Application by North Somerset Council for an Order granting Development Consent for the Portishead Branch Line – MetroWest Phase 1

Hearing Action Points arising from the Compulsory Acquisition Hearing 2 held virtually on Wednesday 3 March 2021

Drawing Title: CATTLE CREEP PROPOSED GENERAL ARRANGEMENT SHEET 1 OF 2

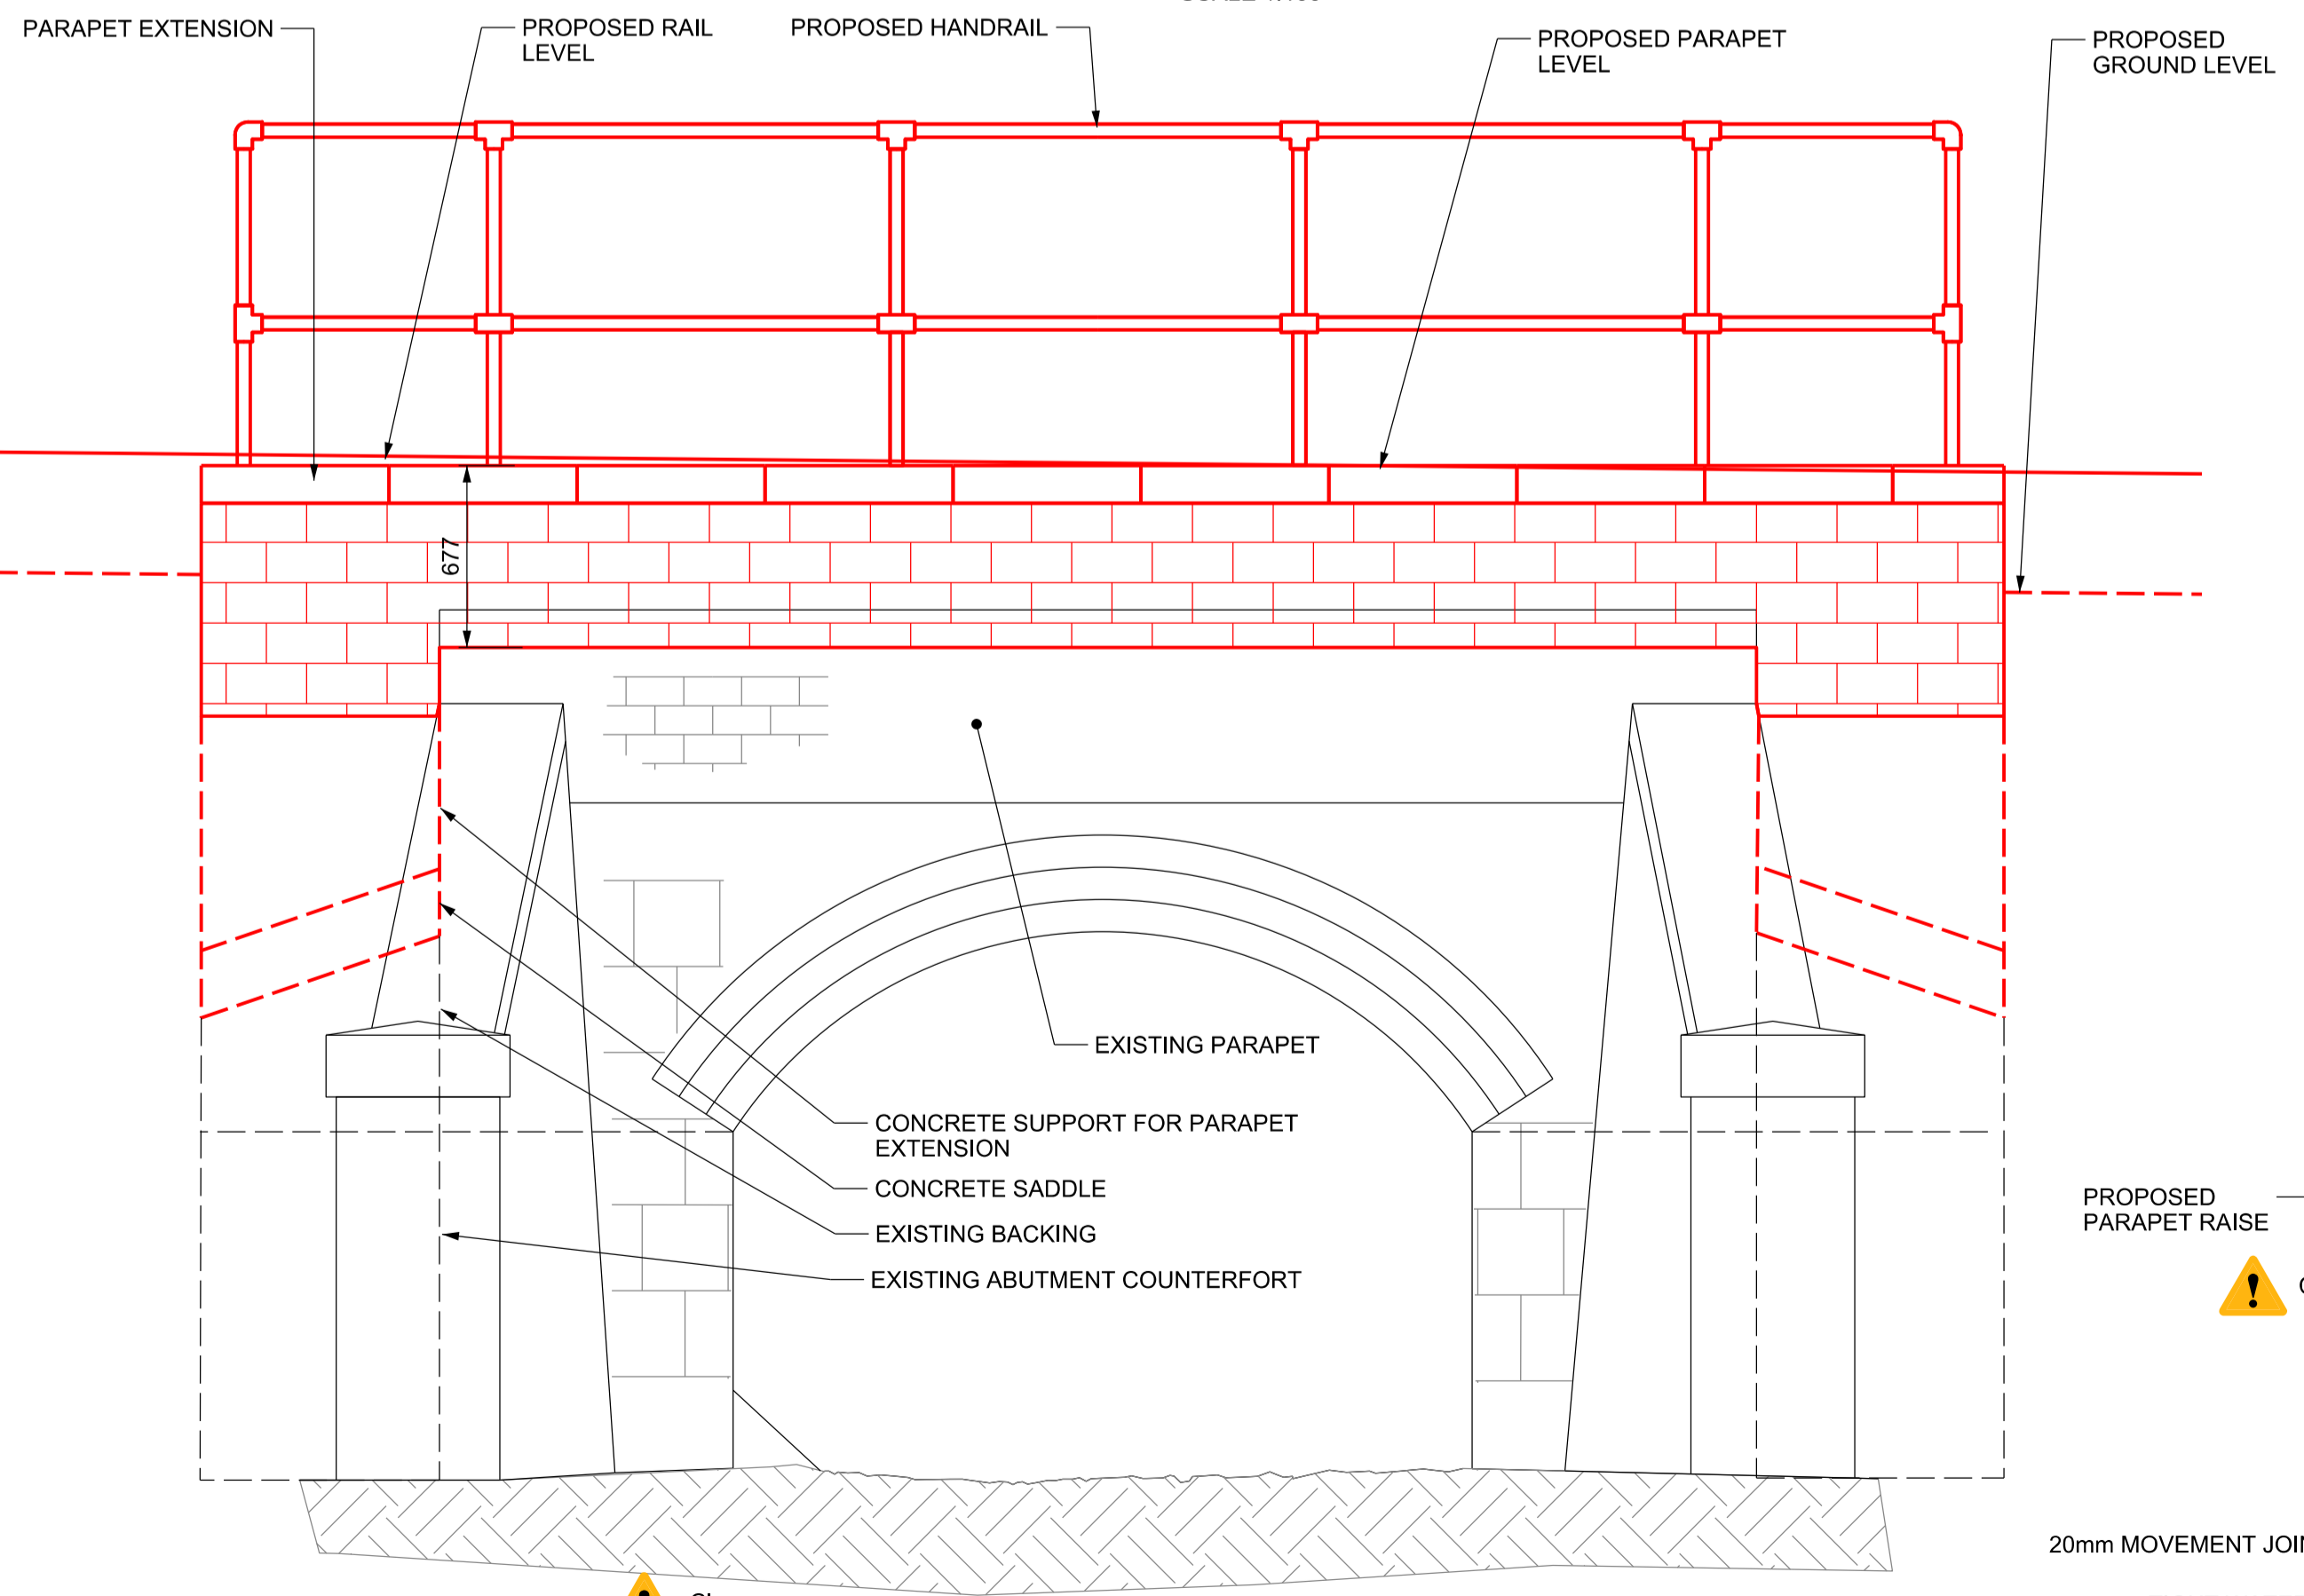
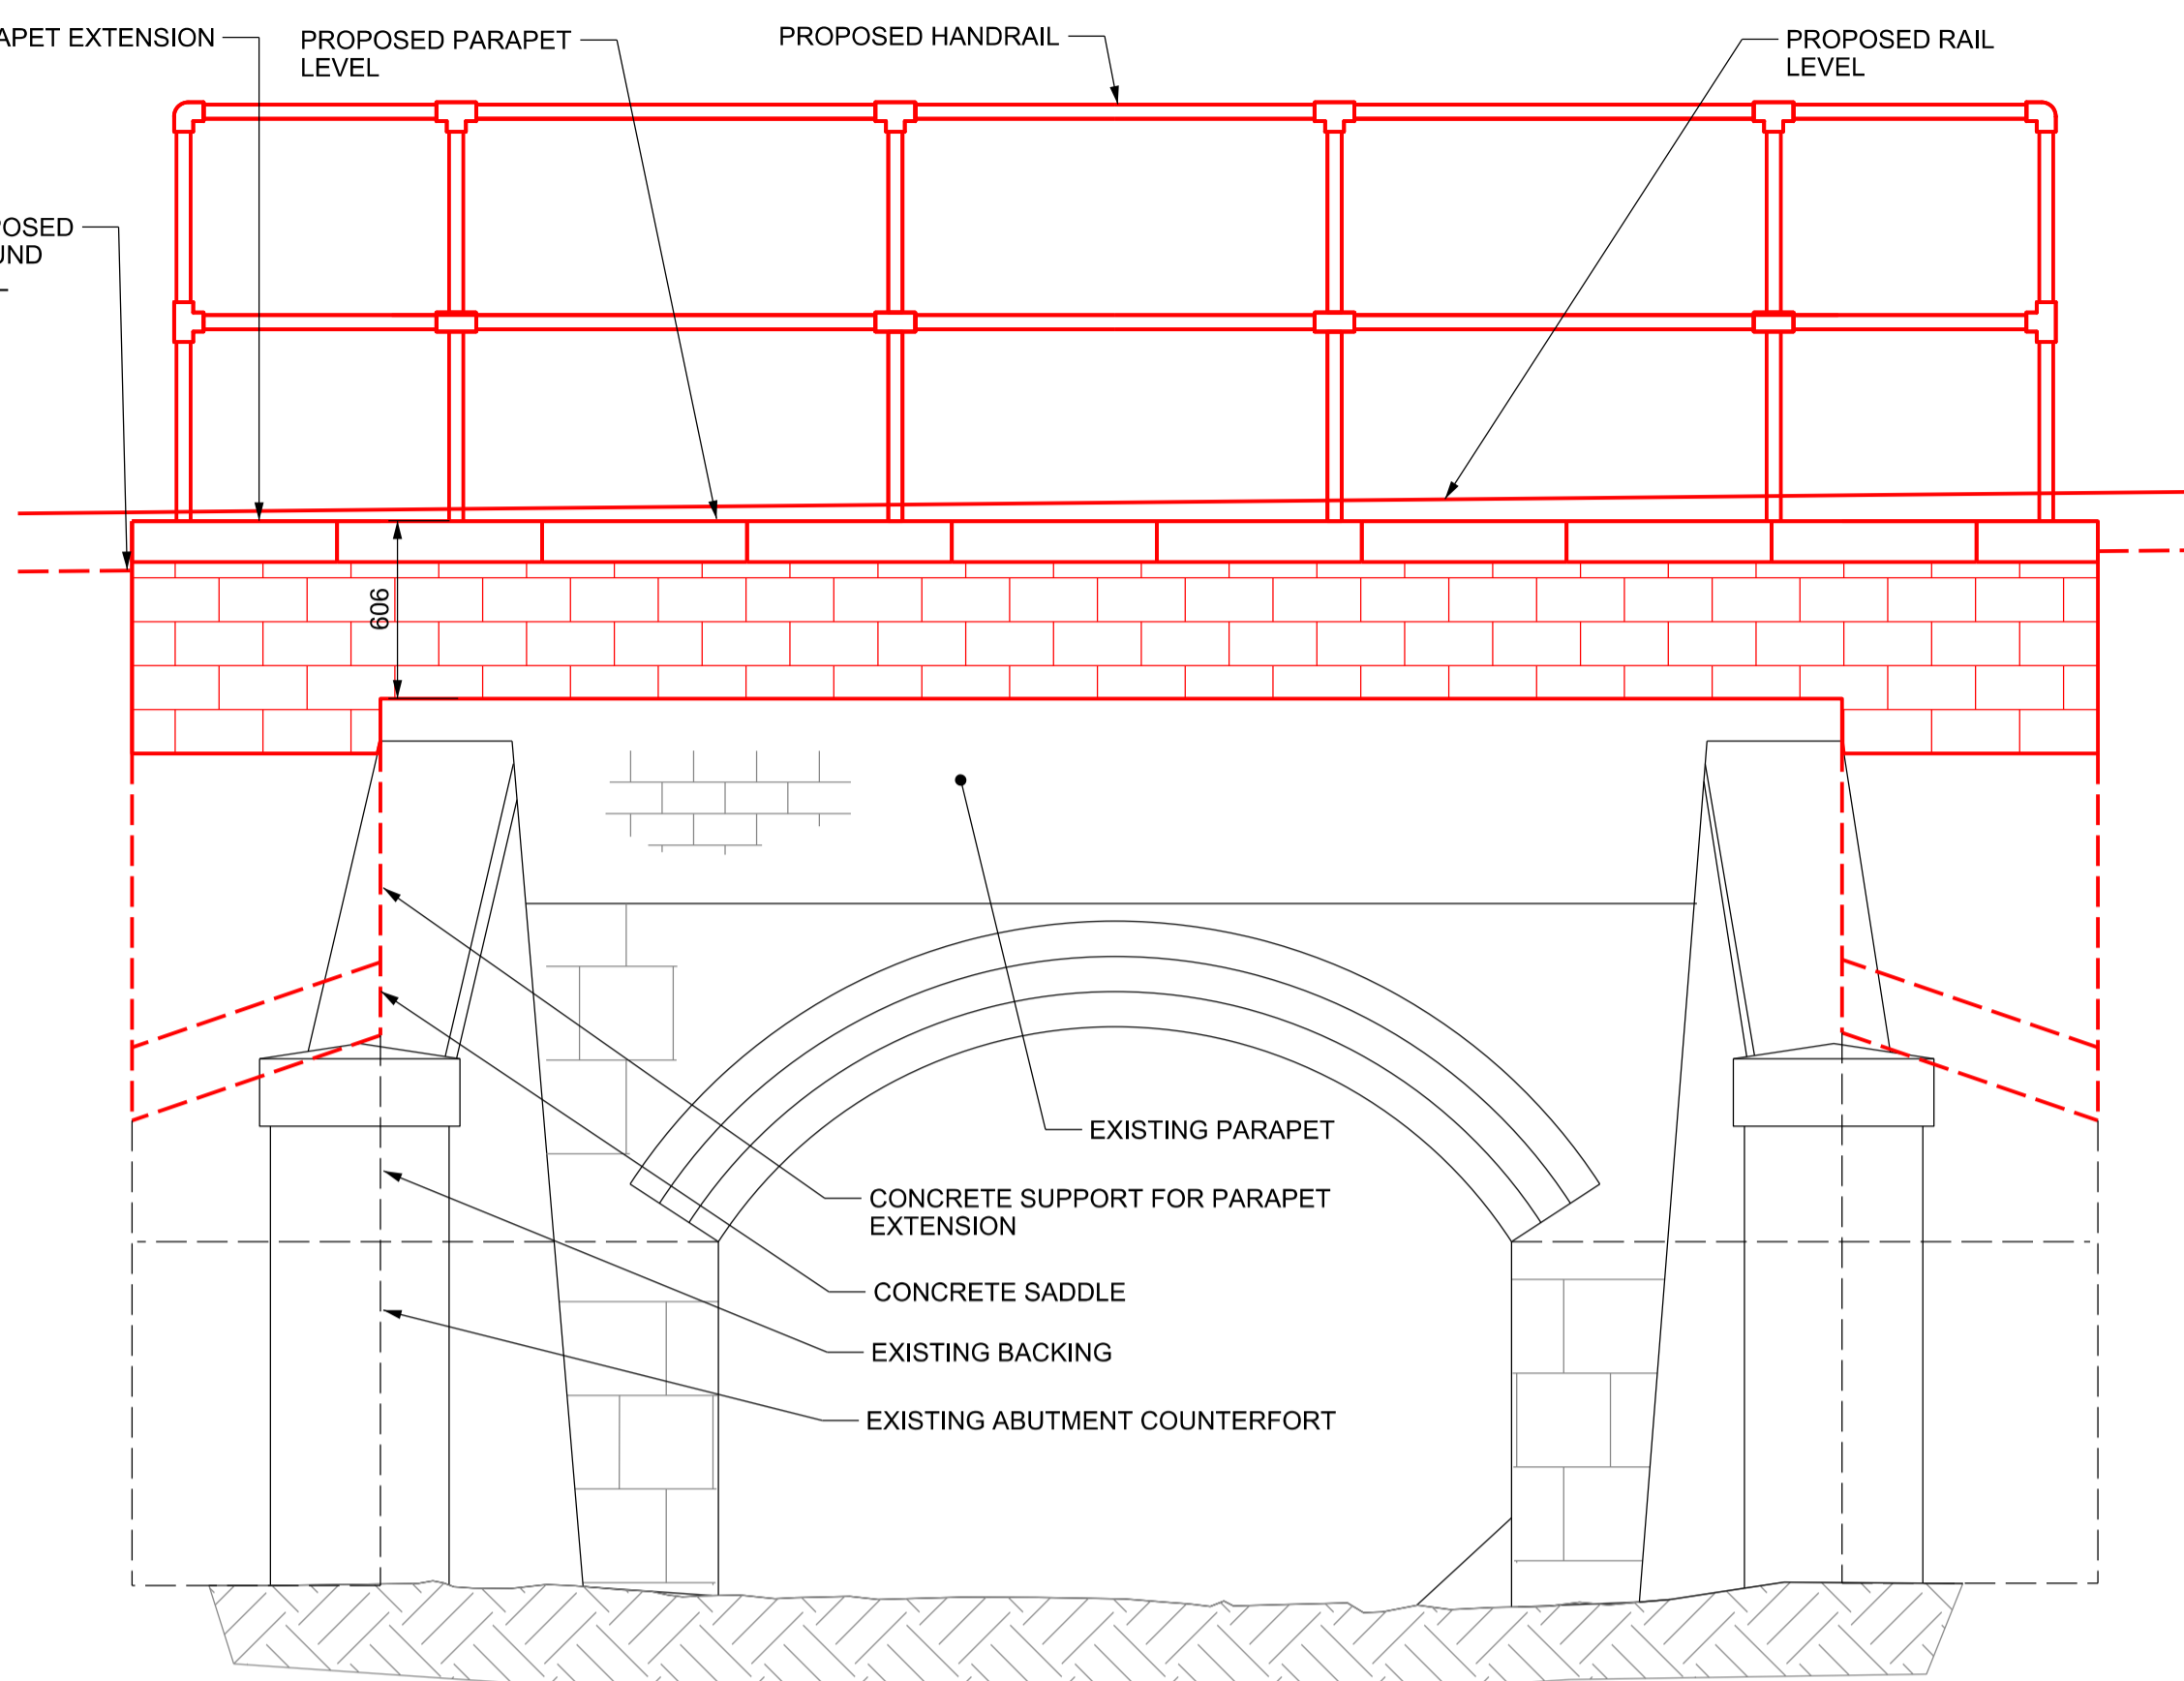
and the CA Schedule or properly cross reference the documents		
9	Provide a written summary of oral case made at CAH	National Grid	Deadline 6
10	Applicant to confirm why the 'bulge' at either end of the proposed access to Cattle Creep Bridge would be needed and to review whether this could be reduced	Applicant	Deadline 6
11	Provide a copy of a plan for the area around the Marsh Lane bridge showing what land is highway land	Applicant/ North Somerset District Council	Deadline 6
